A12 Chelmsford to A120 widening scheme

8.3 Statement of Common Ground with Historic England

Statement of Common Ground with Historic England

Version	Date	Status of Version
P01.1	February 2023	Draft

FIGURE 7.2

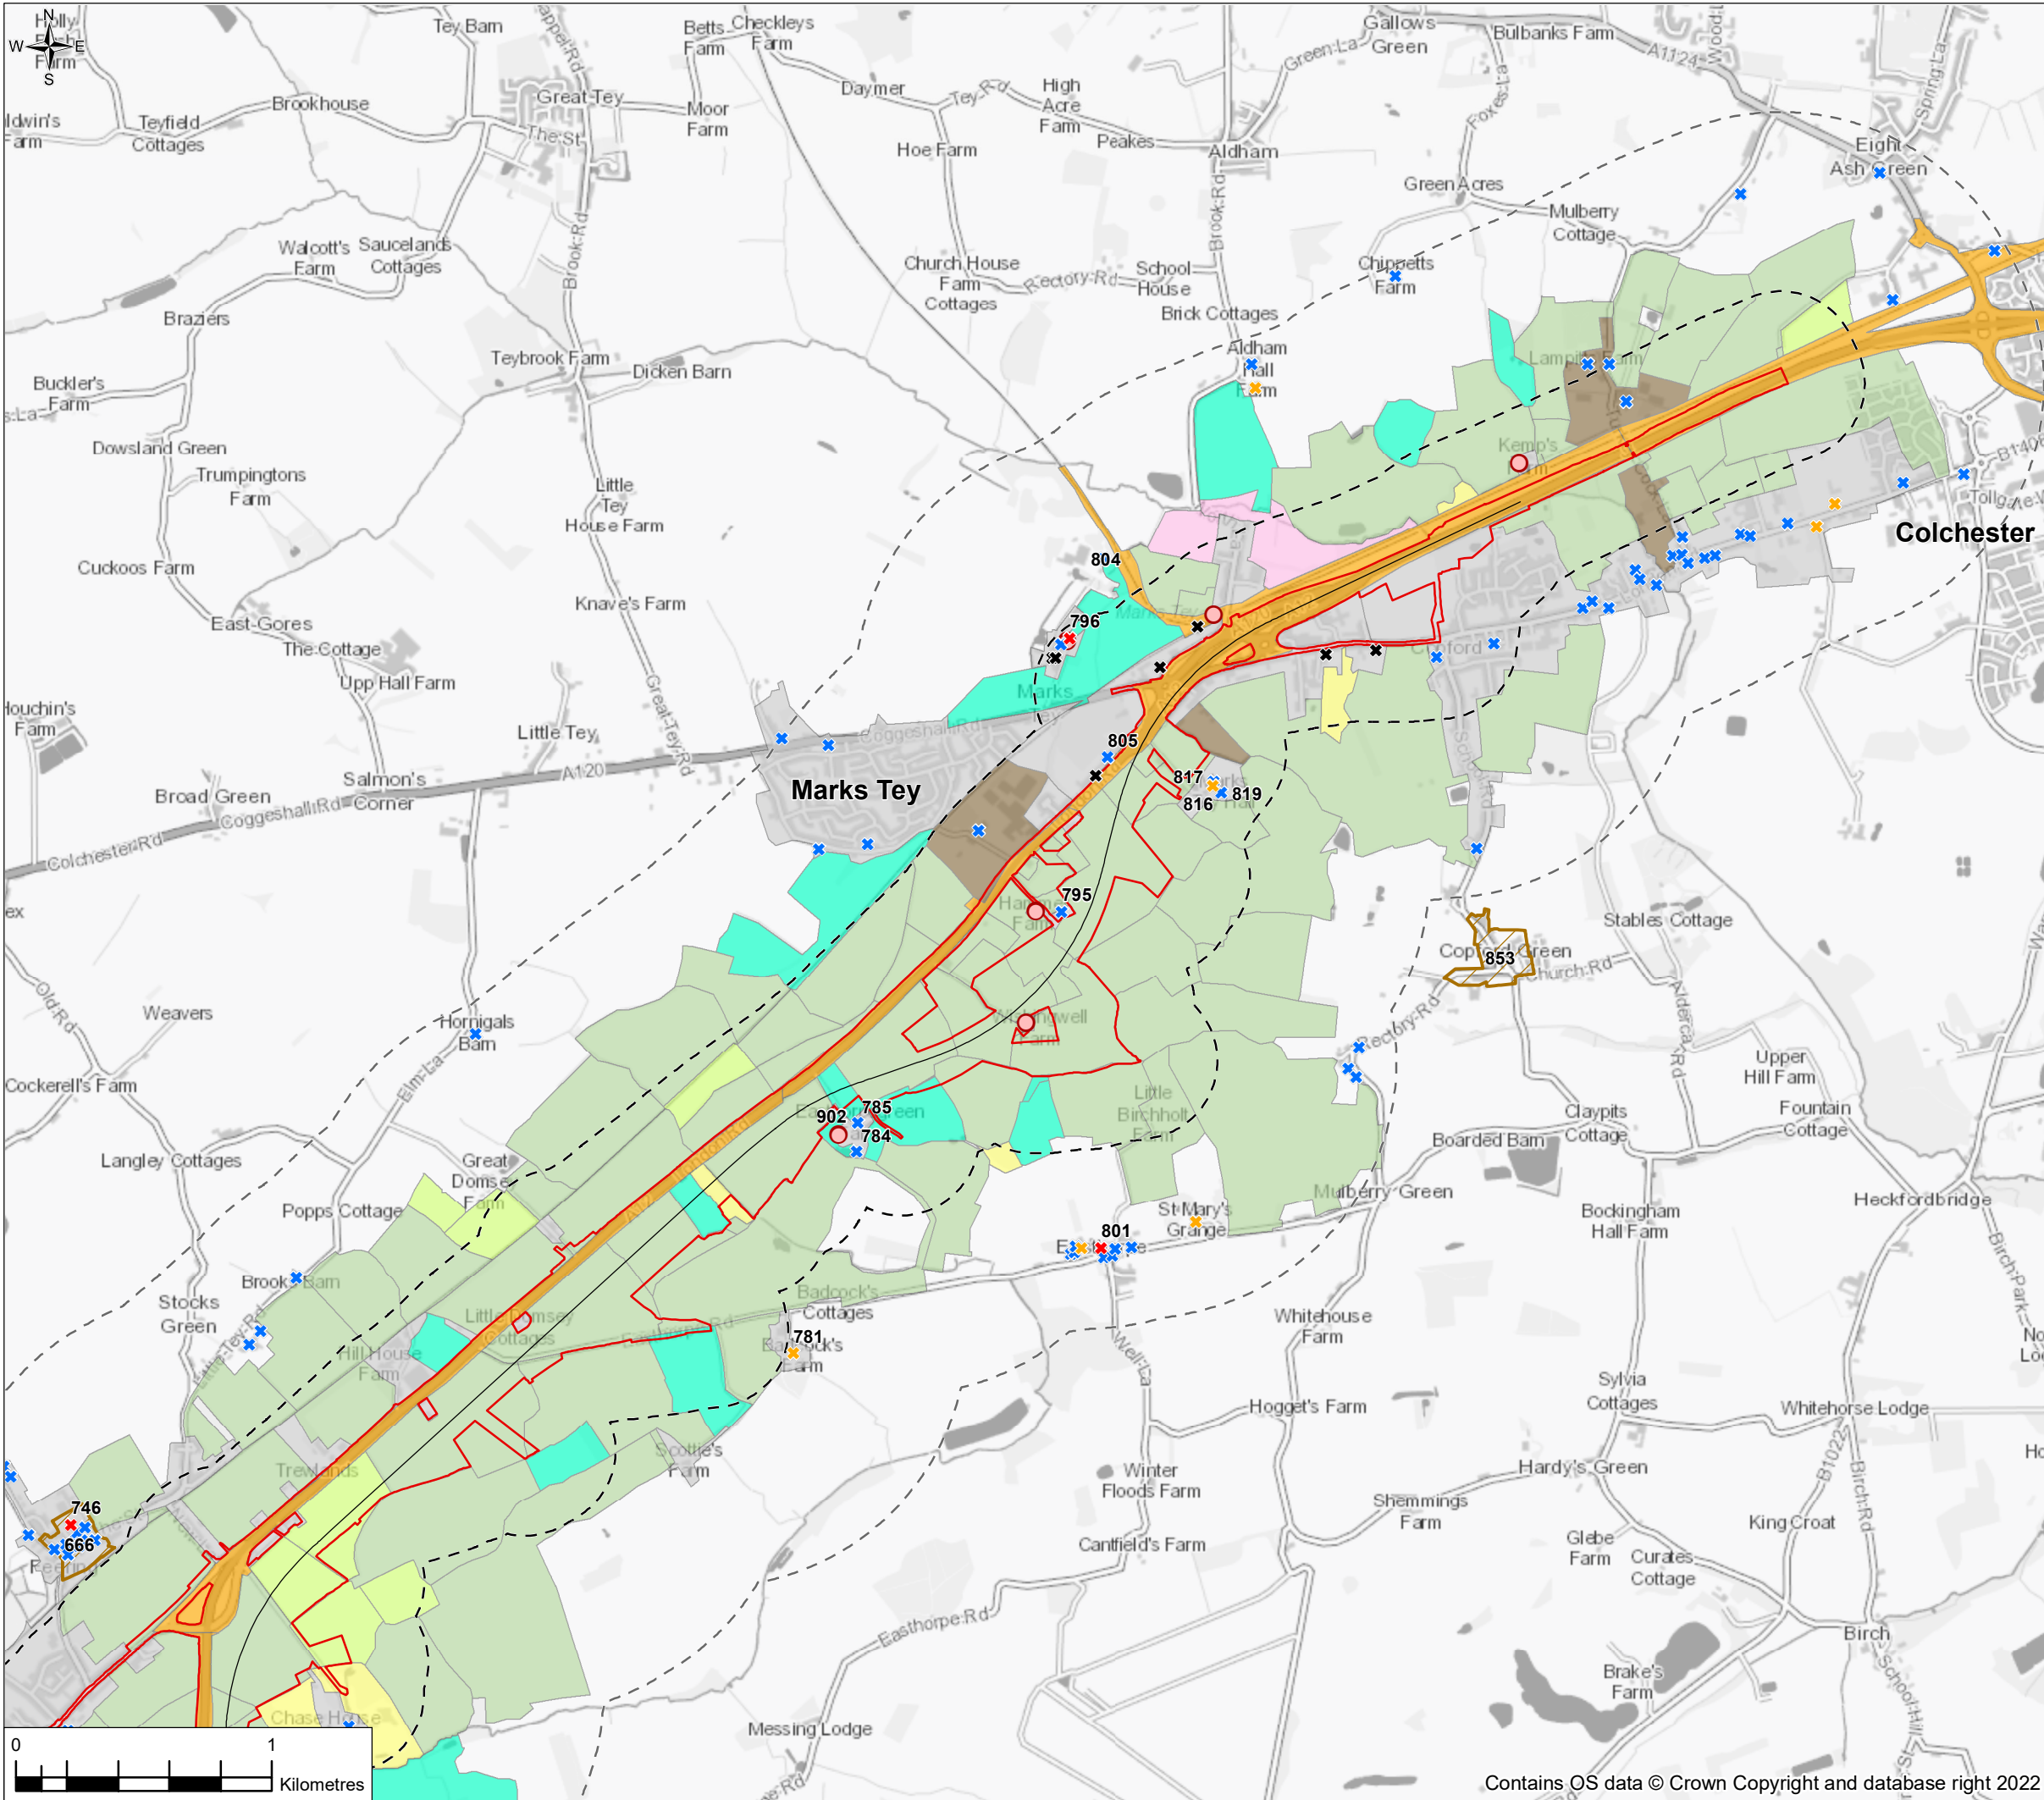
Ref	Issue	Document Reference	Historic England Position	National Highways Position	Status	Date
2.1	Study area for assessment of designated cultural heritage assets	APP-6.1	Historic England stated that the study area for designated heritage assets should extend to 2km based on the preliminary ZTV. If significant effects on the heritage assets beyond 1km are scoped out, this needs to be evidence-based. The assessment study area should be based on the sensitivity of the receiving environment and the potential impacts of the proposed scheme.	A study area extending 1km from the Order Limits has been used to identify designated cultural heritage assets where impacts from the proposed scheme could occur to their setting. Assets have been selected for assessment of potential significant effects on their setting beyond 1km (see Section 7.7 of this chapter) informed by professional judgement guided by the ZTV. Please refer to the ZTV in Figure 8.3 [APP-6.2], which supports the LVIA reported in Chapter 8: Landscape and visual, of the Environmental Statement [APP-6.1].	Under Discussion
